Responses to City Review Comments Dated October 25th, 2023
Cui Preliminary Short Plat
SUB22 – 009

Please refer to the attached Arborist list of detailed responses to the City's Arborist review comments dated October 25th, 2023.

TREE RETENTION CALCULATIONS	
TOTAL VIABLE TREES	22 TREES
TOTAL RETAINED TREES	10 TREES
TOTAL TREE RETENTION	45%

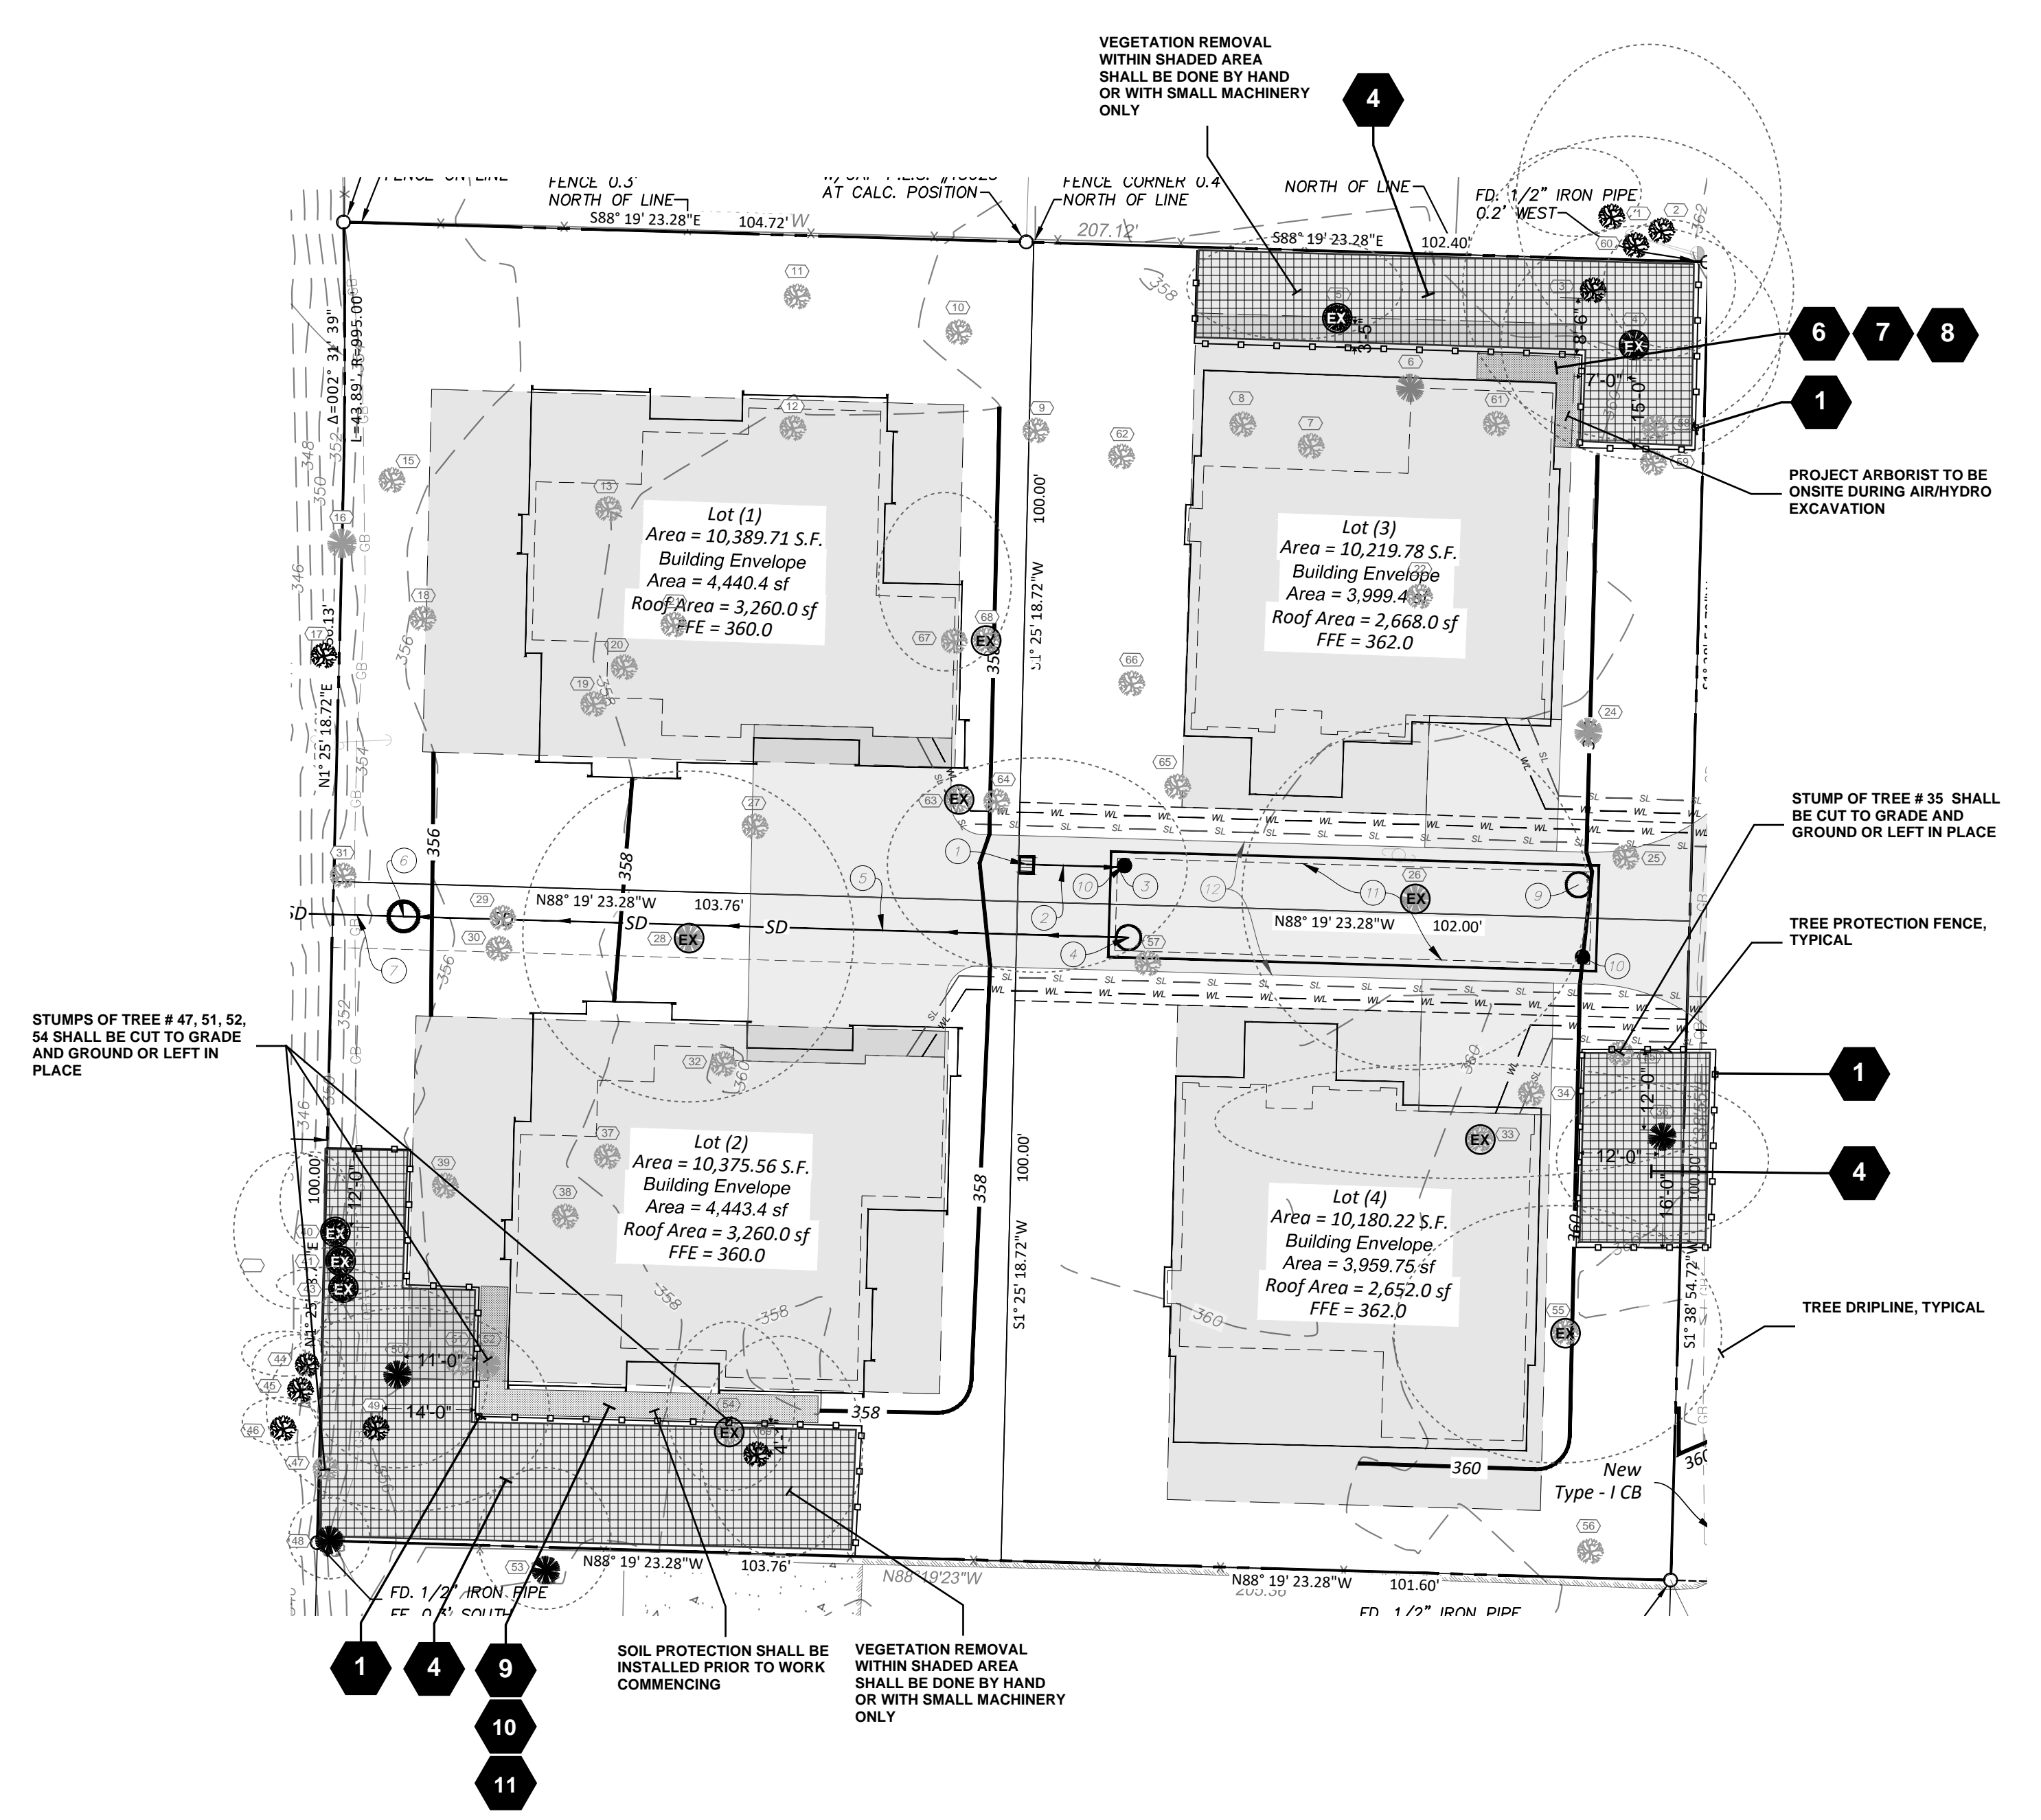
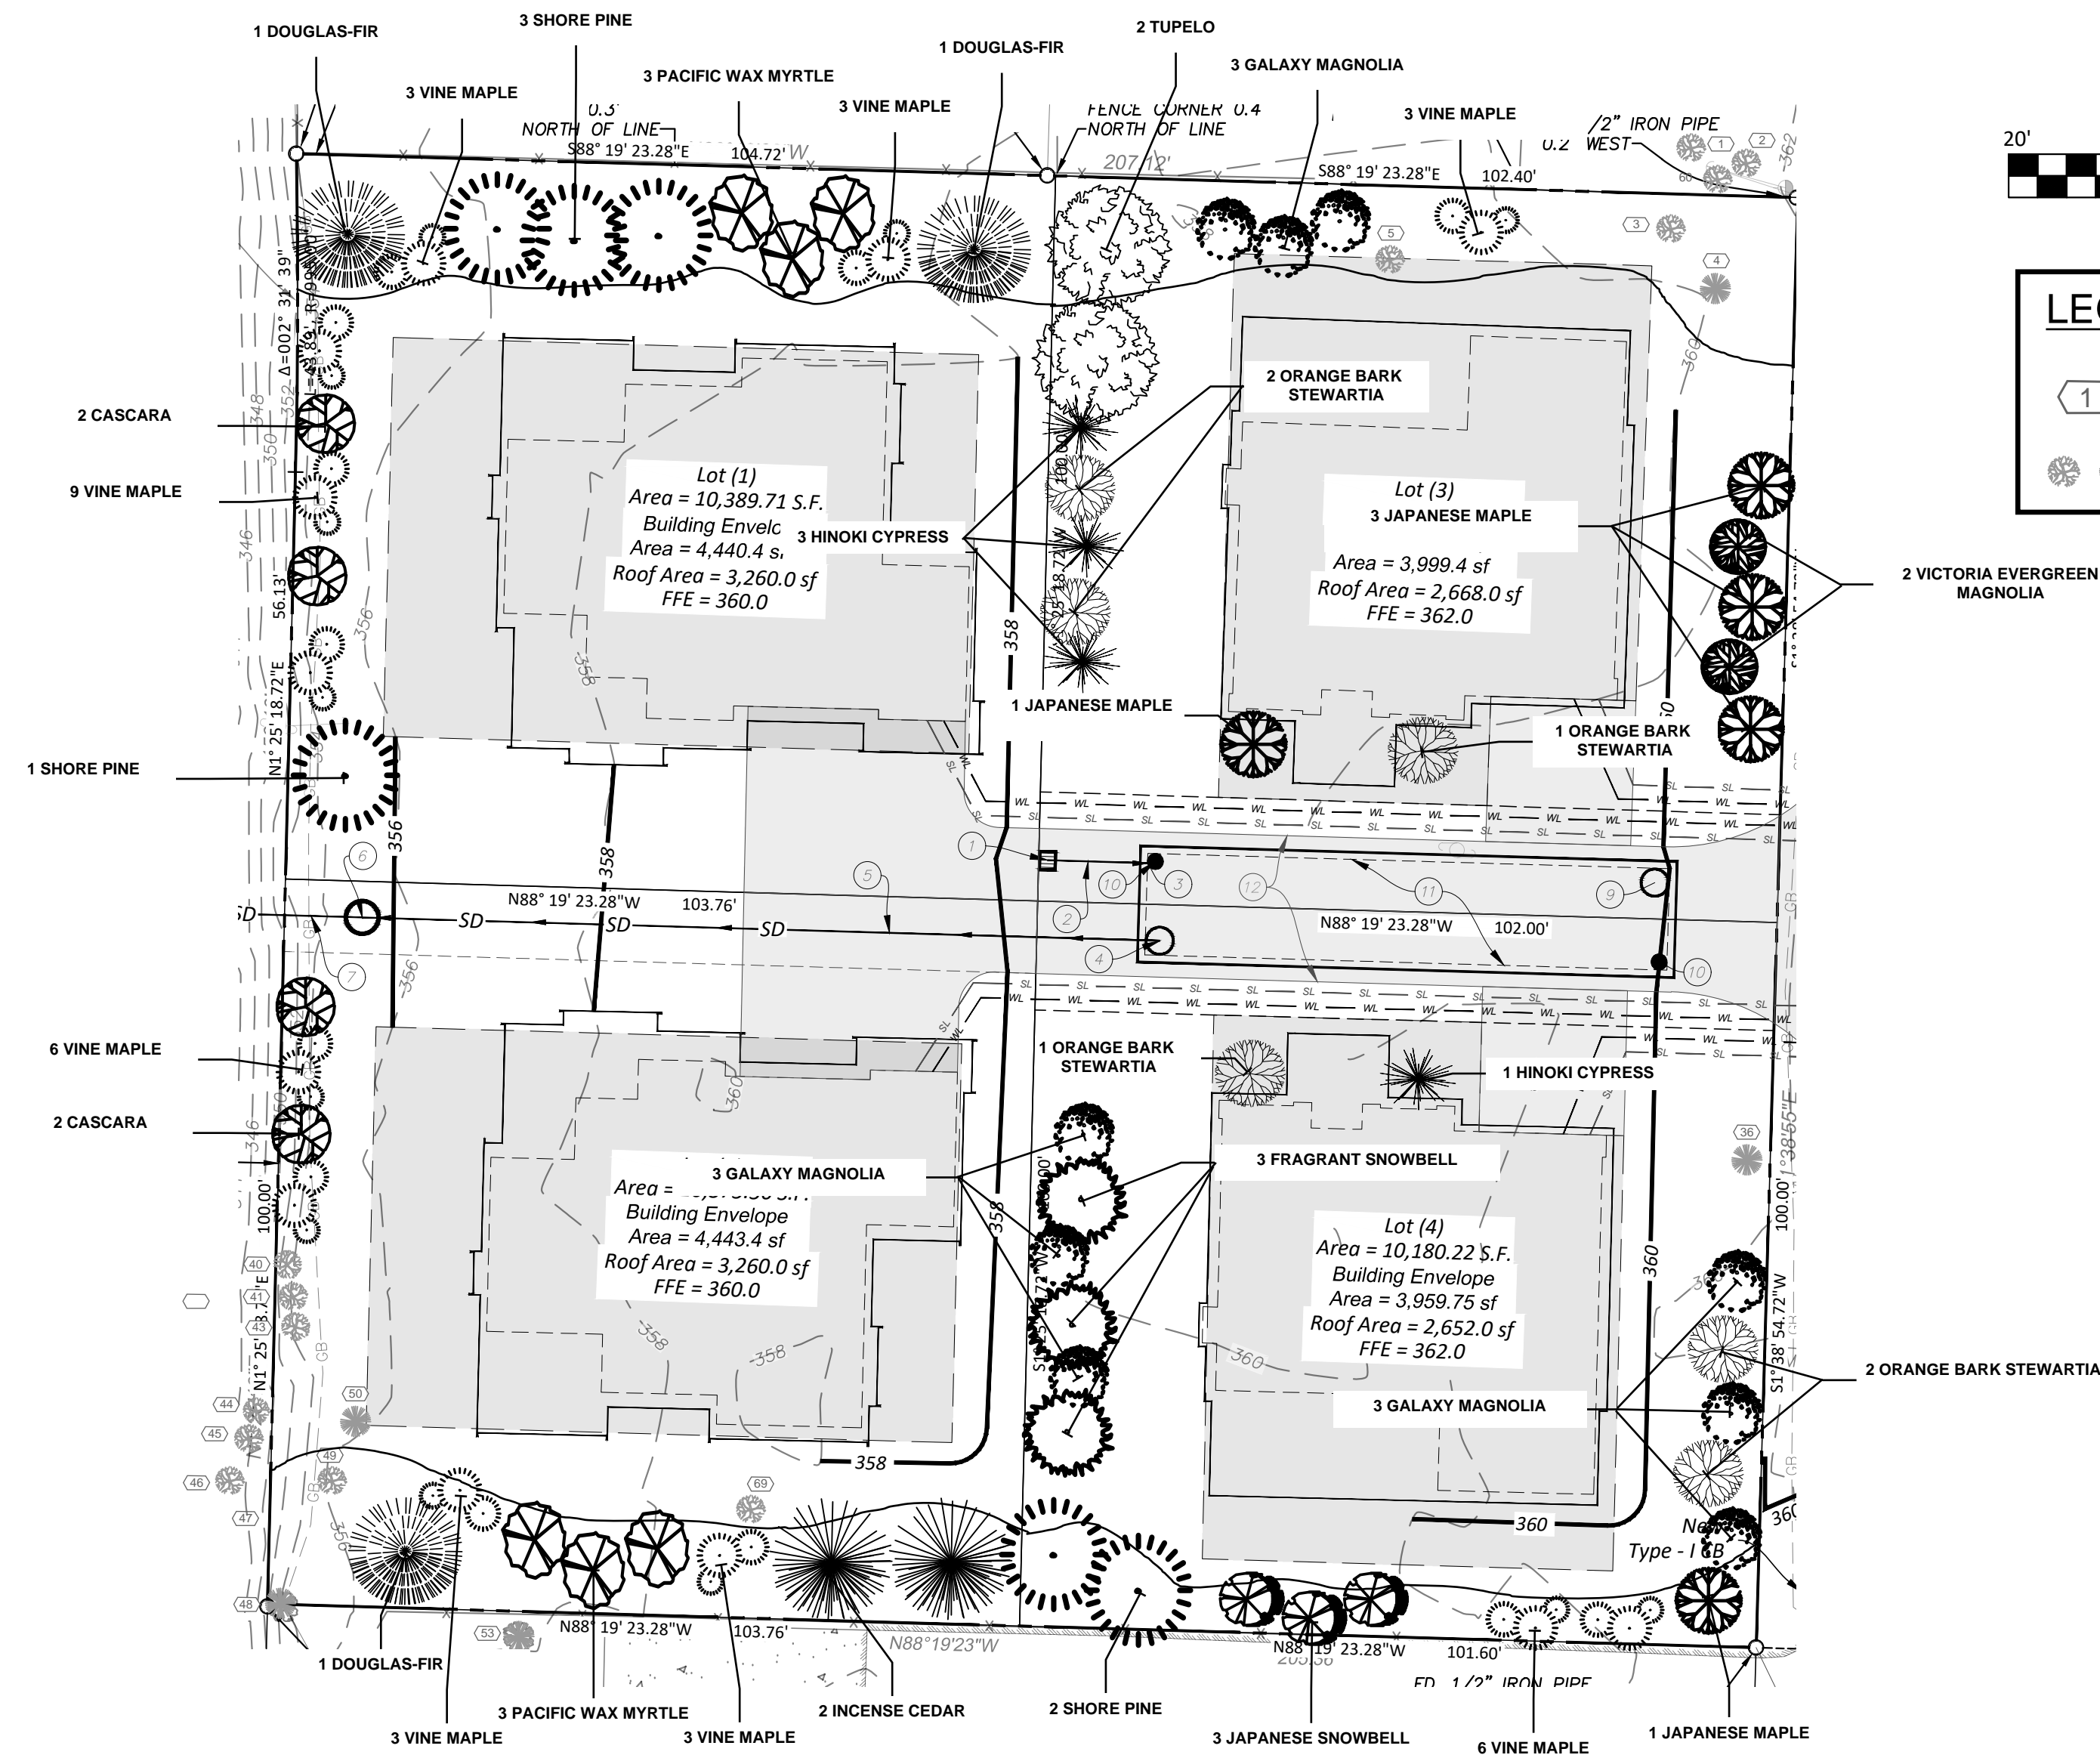
1. We moved the proposed building pad within proposed lot -1 westerly while maintaining compliance with required maximum gross floor area requirement. This action resulted in saving two exceptional trees, number 68 and 63 as shown on the attached revised Civil Plans and attached Trees Retention Plan.

2. We trimmed proposed building pad within proposed lot – 2 while maintaining compliance with required maximum gross floor area requirement. This action resulted in saving one exceptional tree number 54 as shown on the attached revised Civil Plans and Trees Retention Plan.

3. We trimmed proposed building pad within proposed lot – 3 while maintaining compliance with required maximum gross floor area requirement. This action resulted in saving two exceptional trees, number 4 and 5 as shown on the attached revised Civil Plans and Trees Retention Plan.

4. We modified the layout of proposed building pad within Lot – 4 by flipping the proposed house while maintaining compliance with required maximum gross floor area requirement. This action resulted in less impact to surrounding exceptional trees as shown on the attached revised Civil Plans and Trees Retention Plan.

The above reconfiguration to proposed building pads will result in saving 8 exceptional trees out of existing 12 exceptional trees. It is not possible to save the remaining 4 exception trees due to the need of proposed on-site access road, proposed on-site drainage retention/detention vault, proposed on-site storm water conveyance system, and proposed on-site utilities.
